# Householder Proforma

**Application Ref:** 2021/0916  
**Address:** 6 Tanfield Close, Royston, Barnsley, S71 4JH  
**Neighbour Representations:** No  
**Consultations:** None  
**Property Description:** the detached red brick and render property is located in a predominantly residential area, the property is L is shape with a forward garage block projection, the side elevation of the garage block fronts the highway.  
An intervening planting area is located between the back edge of the pavement and the elevation fronting the highway.  
**Proposed Extension:** Erection of single storey extension to the front of dwelling  
**UDP Designation:** Housing Policy Area  
**Local Plan Designation:** Urban Fabric  
**Conservation Area:** No  
**Relevant History:** N/A  
**Acceptable in Principle:** Yes

Dwg No. **P10** Rev. **D**

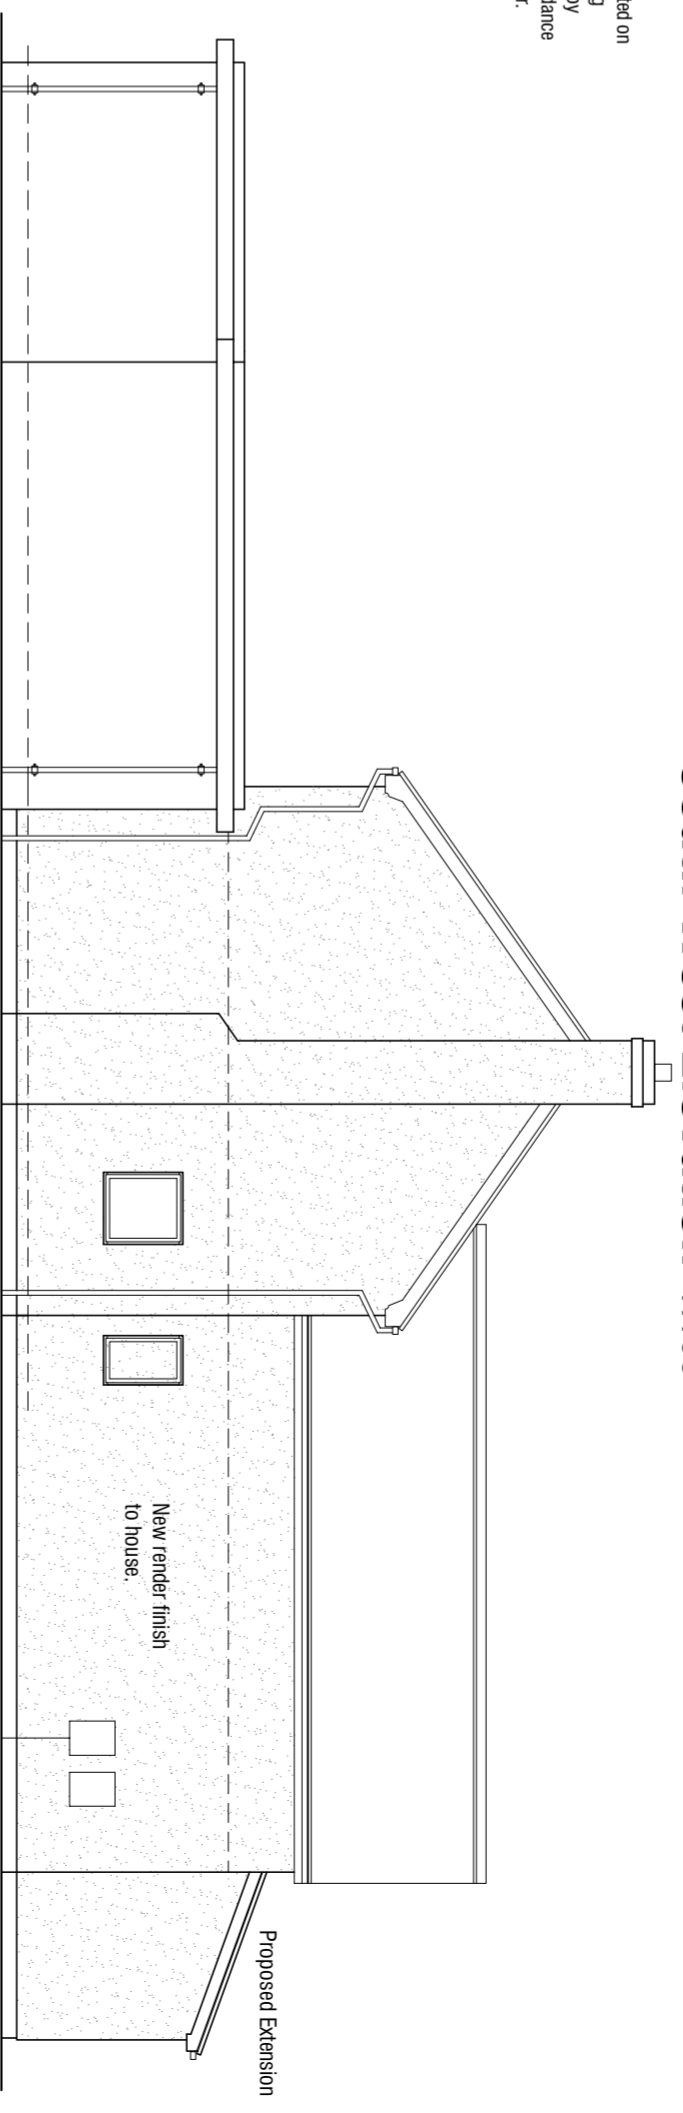
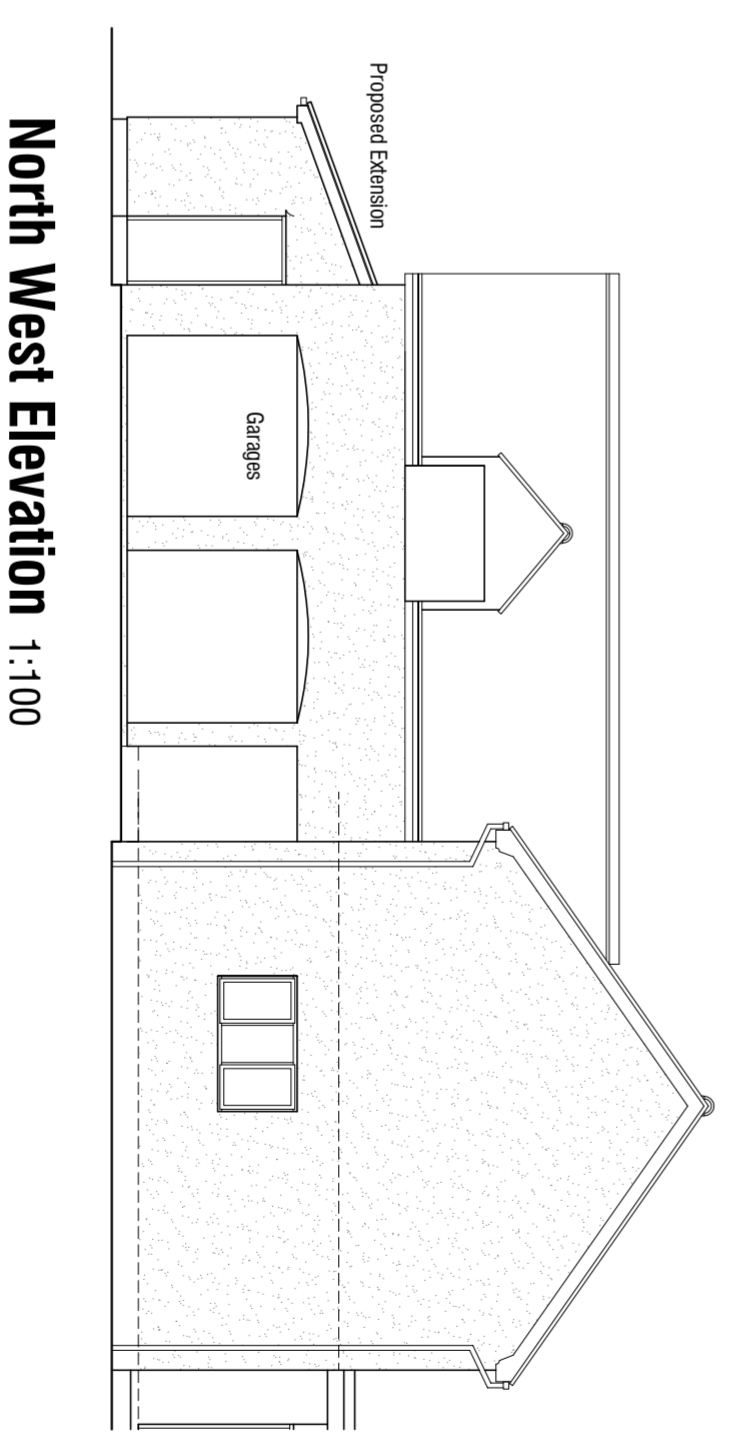
The extension is to be located on the front elevation of the dwelling, on what is effectively the side elevation of the attached garage.

The extension is to project 2.2m from the front elevation and 5.3m along and is designed with a lean to roof at a similar pitch to the main dwelling and is to be rendered to match the original property.

It is acknowledged that the elevation facing the highway is blank, however the extension is to serve as an extension to the existing garage block and would not necessarily require windows and doors; as mentioned previously the dwelling is located at an angle to the

highway with the main elevation of the dwelling set back from the highway and screened by the existing shrubbery.

It is also proposed to render the dwelling; the existing dwelling is a mix of render and red brick, render is characteristic of the dwelling and the wider street scene and as such would not be out of place.

It is therefore considered that the proposed extension and rendering of the property are acceptable and in compliance with Local Plan Policies GD1 and D1
